Subject: SUB22-006 Premium Homes Mercer Island Short Subdivision

Request for information #1

7216 93rd Ave SE

Andrew- Your comment letter from December 22, 2022 has been pasted below. Our responses have been added in red text following each comment. Please note additional responses may be provided by other consultants.

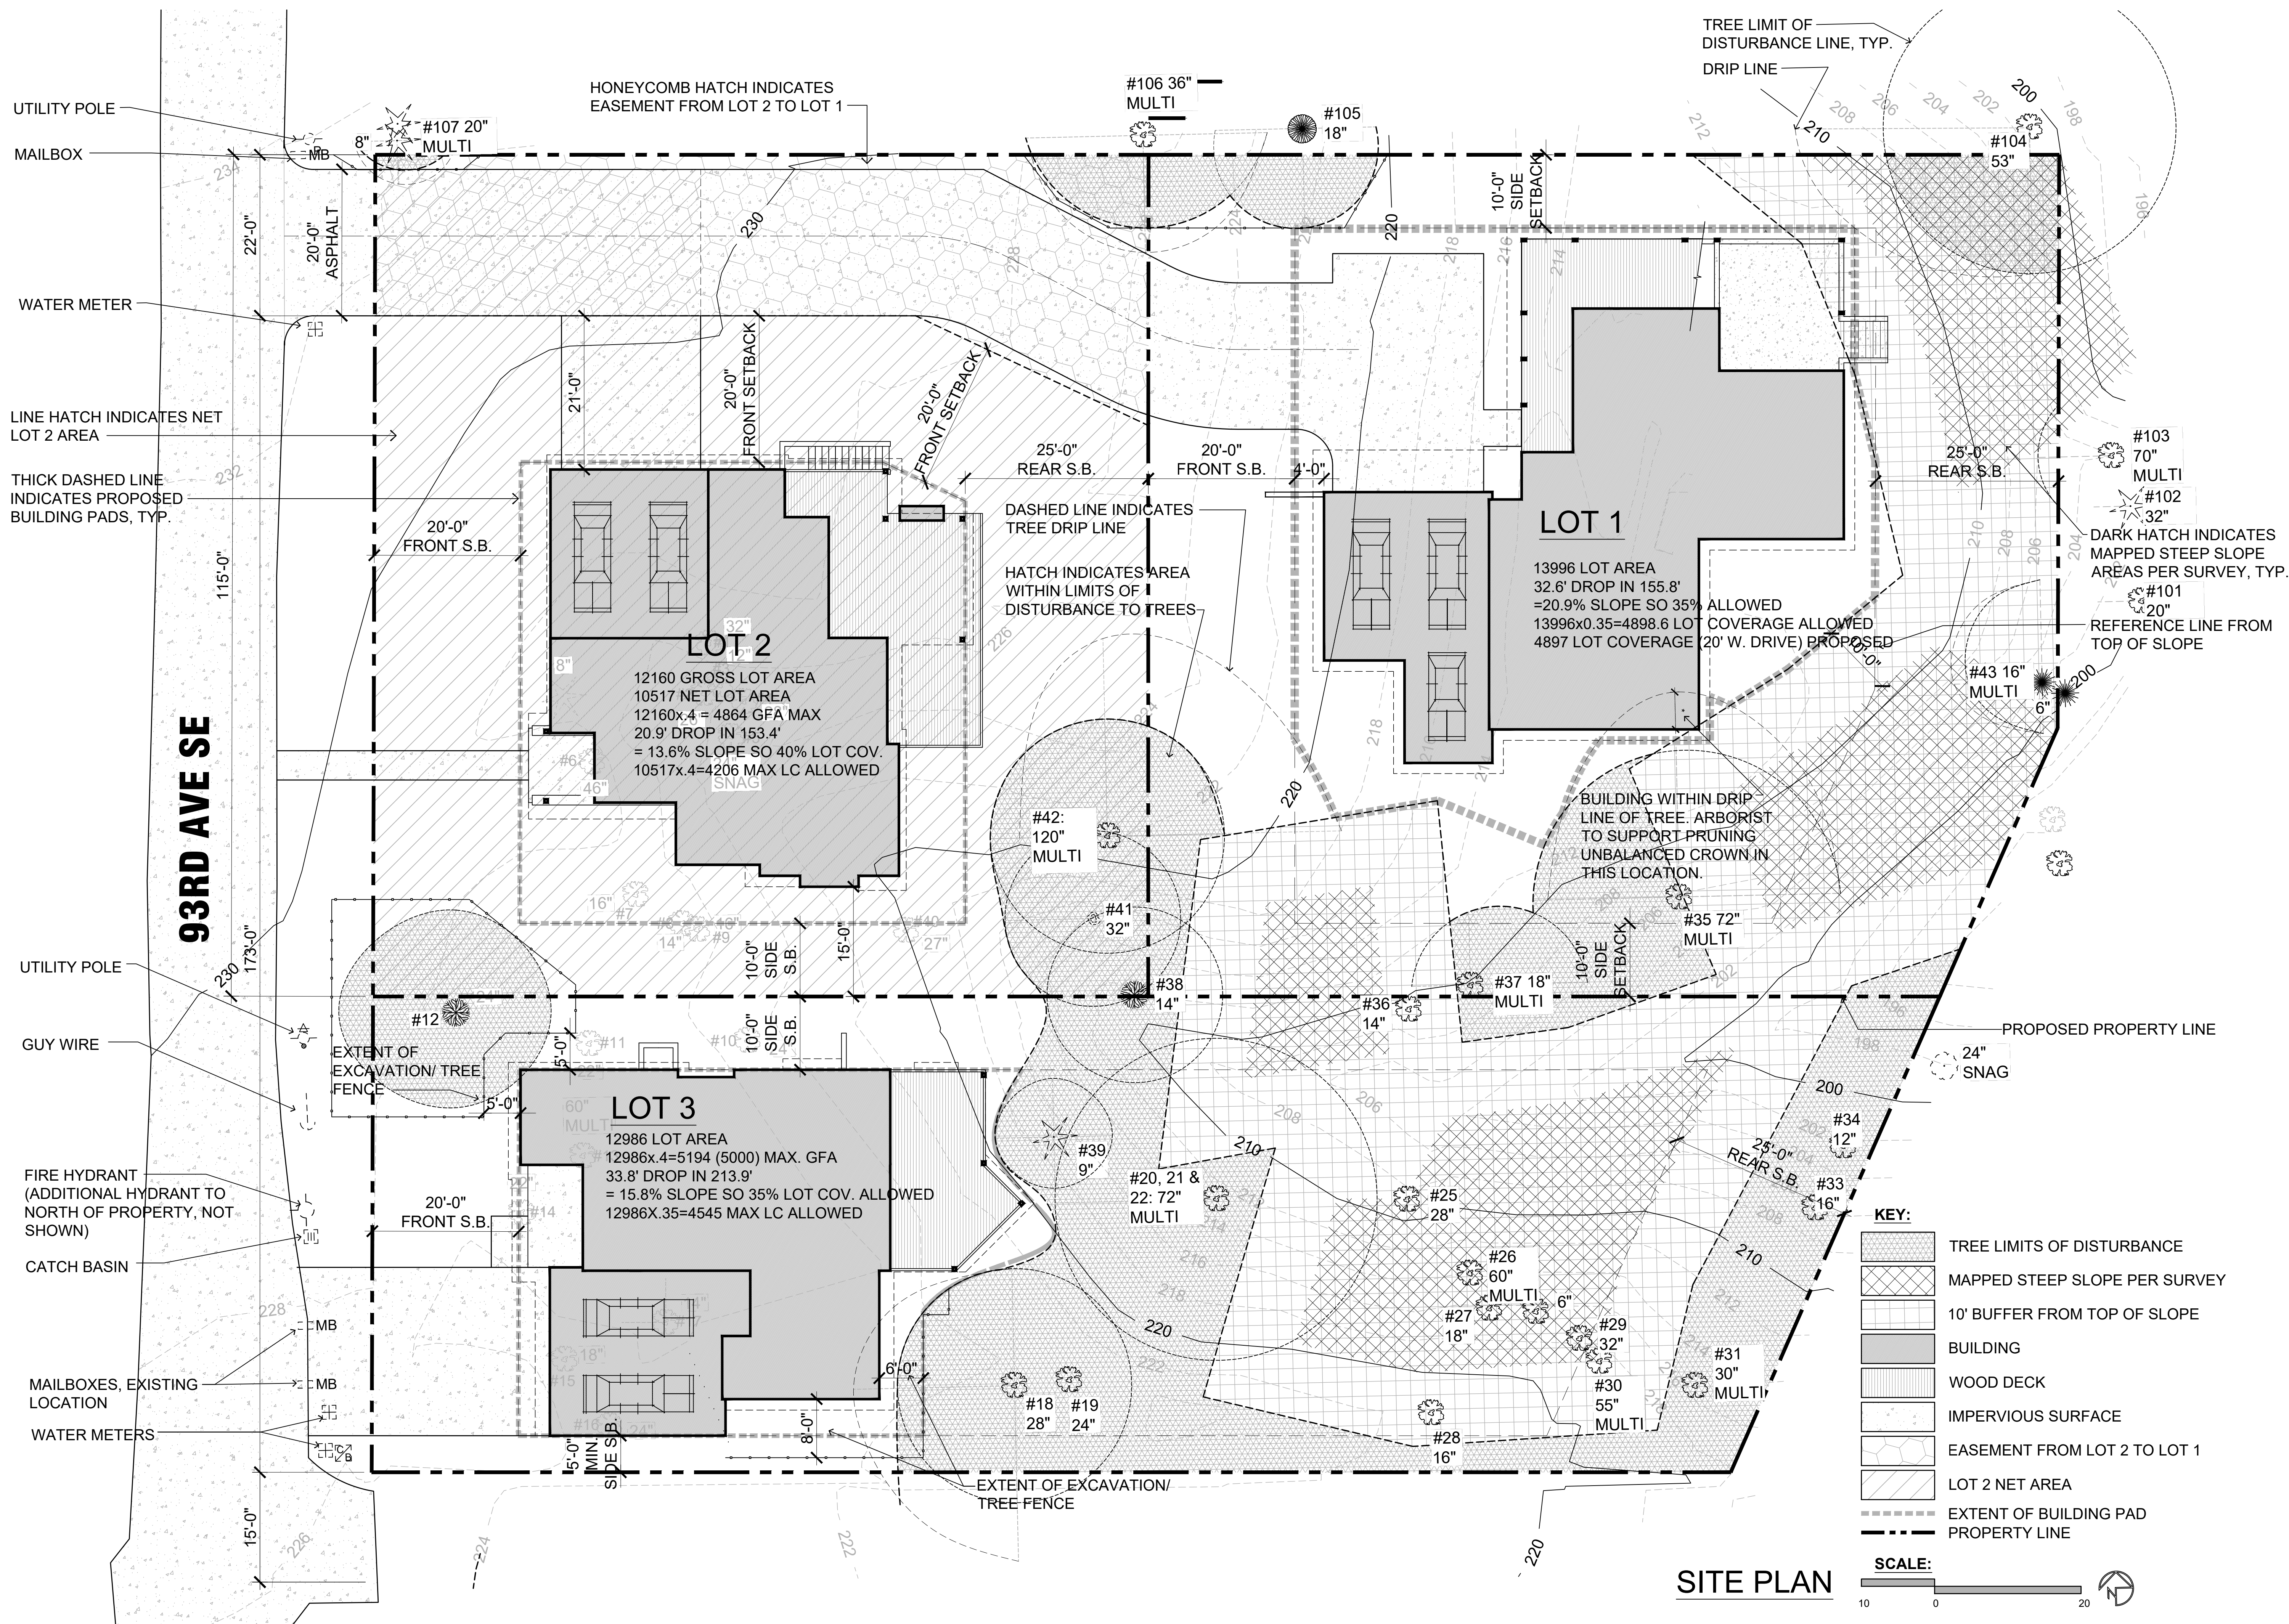
3. Please make the following corrections to the building pads shown in the plan set:

- Lot 1: The building pad for Lot 1 encroaches into the required 25-foot rear yard setback. MICC 19.09.090(A)(2)(a) requires that building pads must be located outside of required front, rear, and side yard setbacks. Please revise the building pad of Lot 1 so it is outside of all required yard setbacks. **The lot 1 building pad has been revised to be outside of all required yard setbacks.**

- Lot 2: Lot 2 is at the intersection of two streets (93rd Ave SE and the private access easement leading to Lot 1). Therefore, Lot 2 is a corner lot, as defined in MICC 19.16.010. MICC 19.02.020(C)(2)(a)(ii) states that the front yard of the corner lot shall be measured from the narrowest dimension abutting a street. In the case of Lot 2, the narrowest dimension abutting the street is the yard to the north. As such, the setbacks for Lot 2 must be as follows:

- The 20-foot front yard setback must be measured from the access easement on the north side of the lot.
 - The 25-foot rear yard setback must be measured from the south property line.

- The side yard setbacks must add up to 17% of the lot width, with a minimum side yard depth of 33% of the required total side yard setback.

Please revise the building pad of Lot 2 to account for the required corner lot setbacks.

- Lot 3: The plans show 5-foot side yard setbacks from both side property lines of Lot 3. MICC 19.02.020(C)(1)(c)(i)((a)) states that for lots with a lot width of 90 feet or less, the sum of the side yards' width shall be at least 15 feet. Please revise the building pad of Lot 3 to account for the side yard setback requirements. **Lot 3 now shows a 10' side yard setback on the north and a 5' side yard setback on the south.**
- Please note that under MICC 19.09.090(A)(1)(a) all building pads must prevent the removal of trees and vegetation required for retention pursuant to Chapter 19.10 MICC. **Noted. There do not appear to be any conflicts with building pads and required vegetation retention.**

Lot 2 now has corner lot setbacks applied. Front setbacks are from 93rd Ave on the west side and the driveway easement on the north side. The south side has a 10' side setback. Per 19.02.020.2.a.ii.(a) the 25' rear yard setback is applied to the east.

TREE REMOVAL, RETENTION & PLANTING PLAN

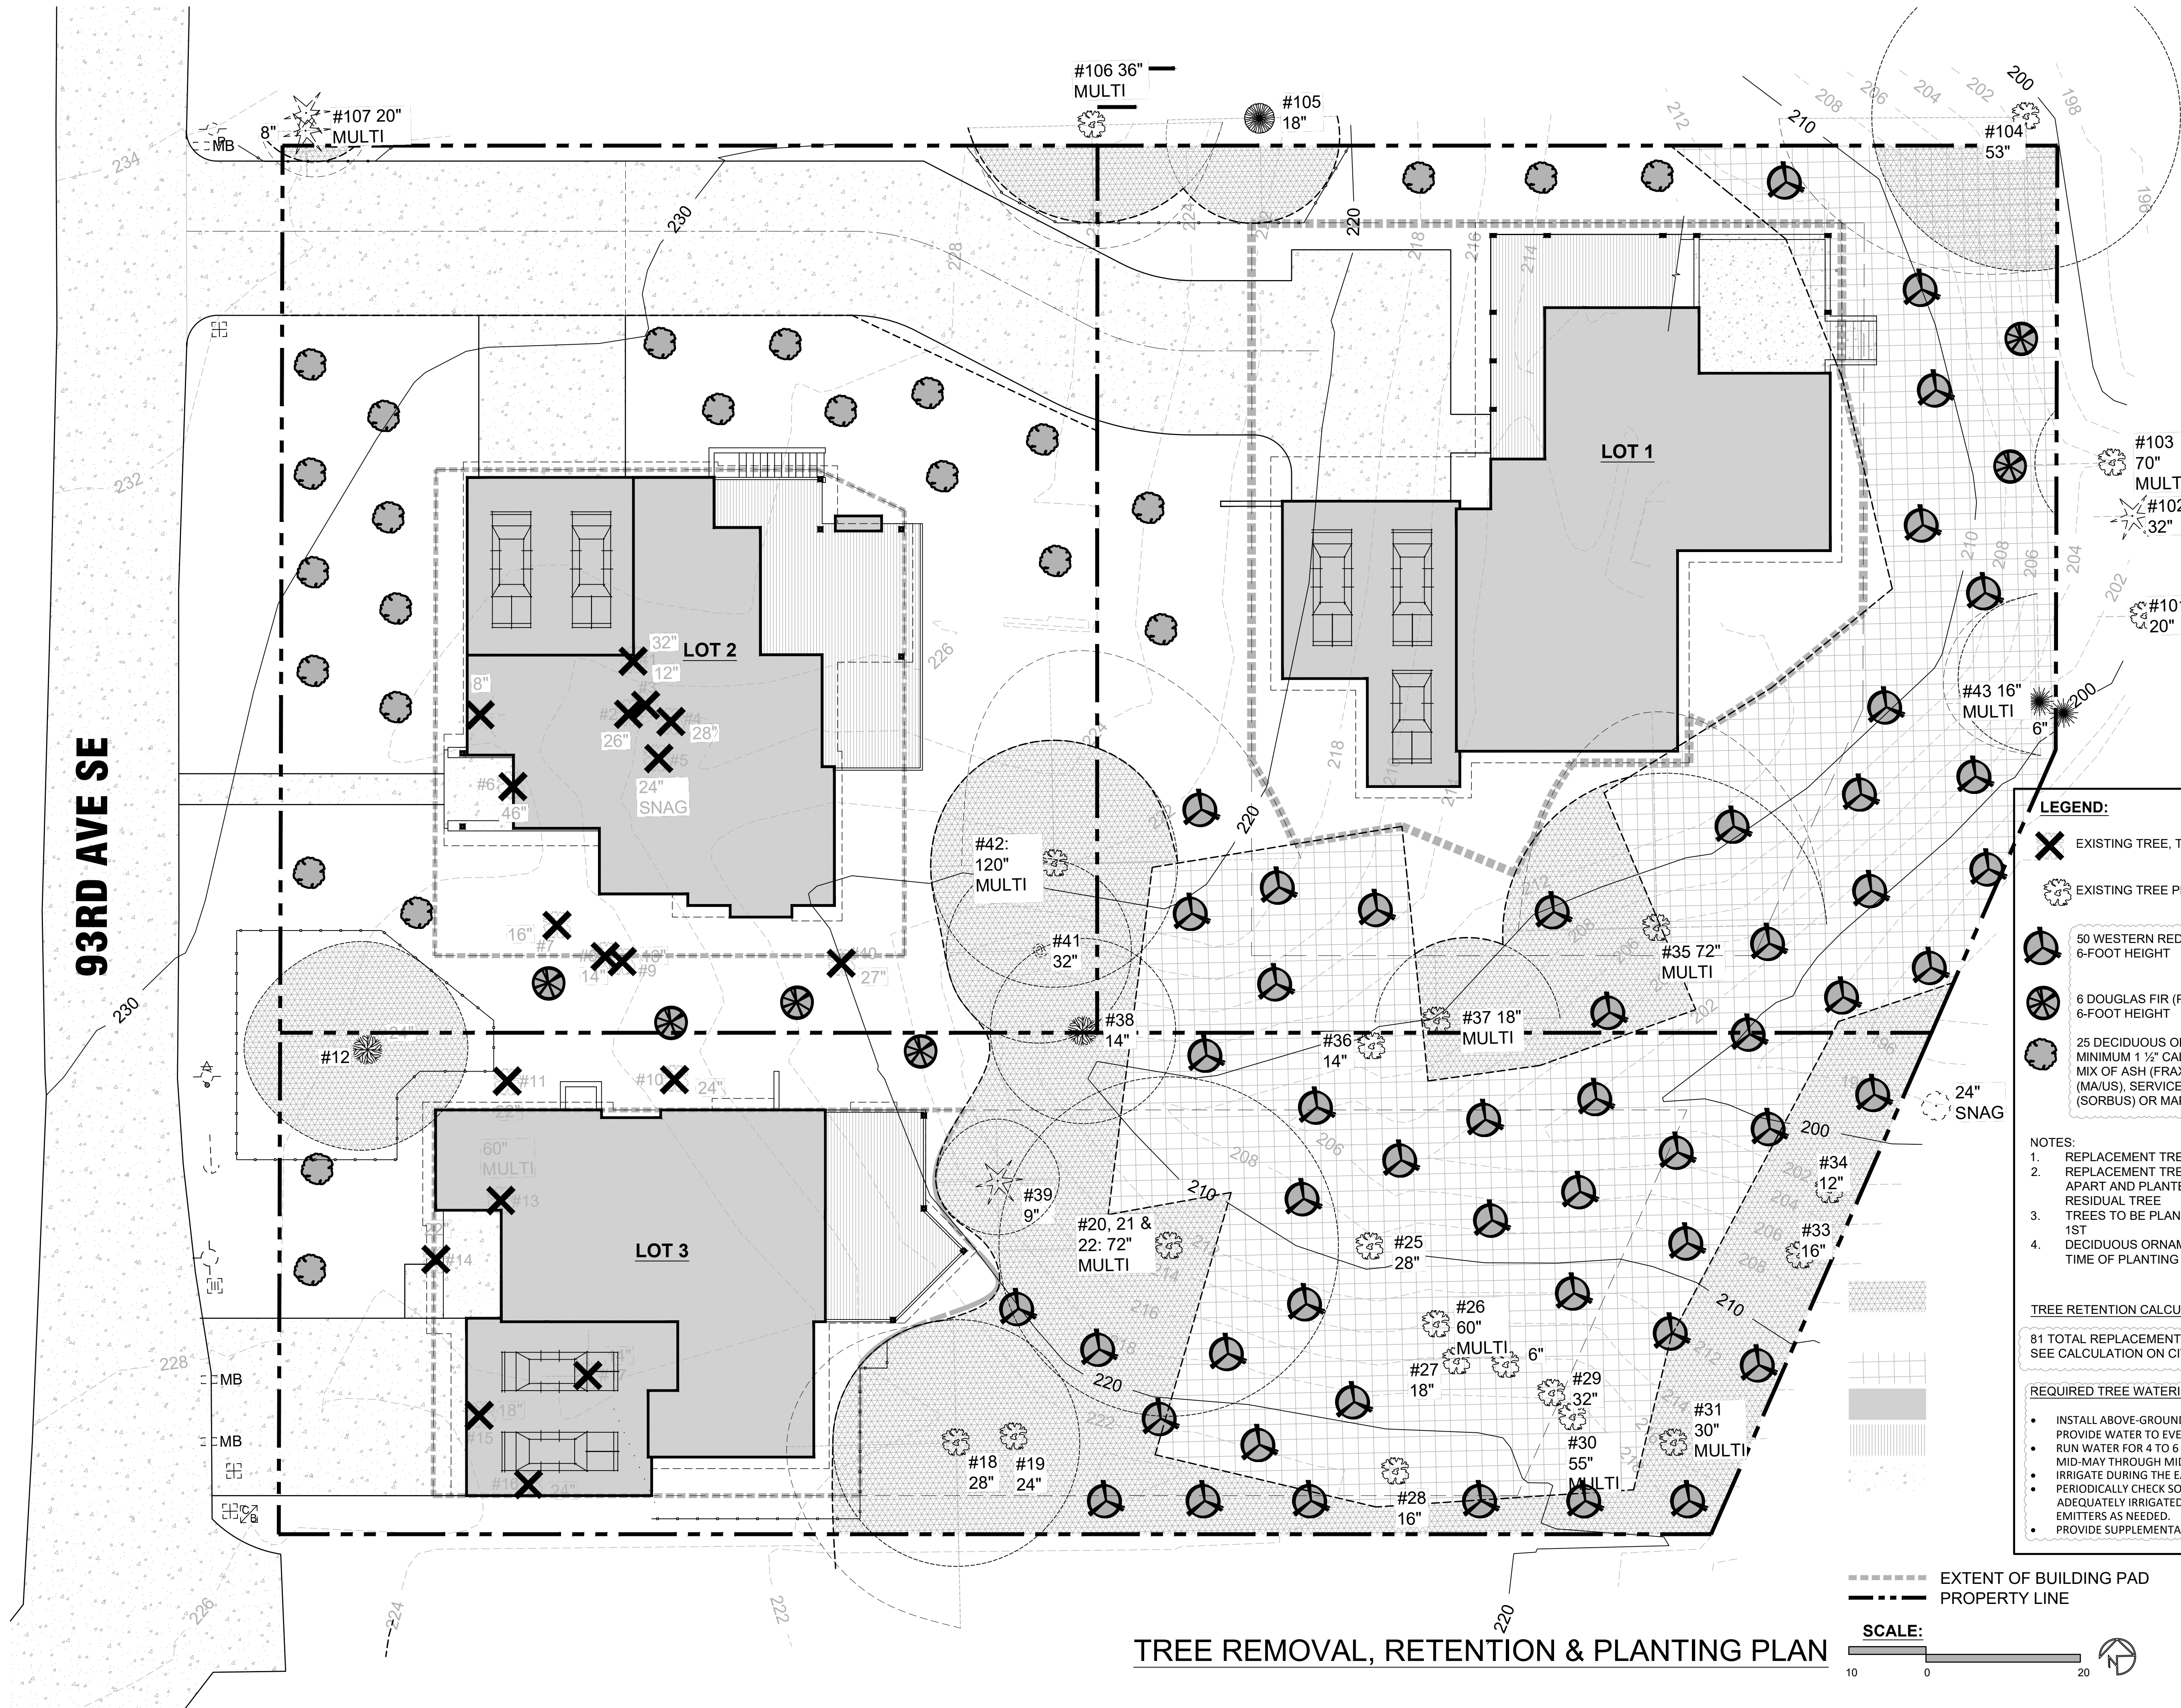
2. (For landscape architect) The application material shows that 74 replacement trees are proposed. 81 trees are required to be planted, assuming that Tree 12 will be retained. If the removal of Tree 12 can be justified under MICC 19.10.060, an additional 6 trees will need to be replanted. At least half of the trees will need to be native to the Pacific Northwest. The trees will need to be at least 10 feet apart from each other, structures, fences, and utilities. If requested, and if you can demonstrate that no room exists on site for all the trees, you can request that the remainder be a fee in lieu. A tree watering plan must be submitted to ensure the trees survive long term. **Calculations have been revised on the civil drawings and sheet A1.1 to show 81 required replacement trees. Trees are located on sheet A1.1. Tree watering plan notes have been added to sheet A1.1.**
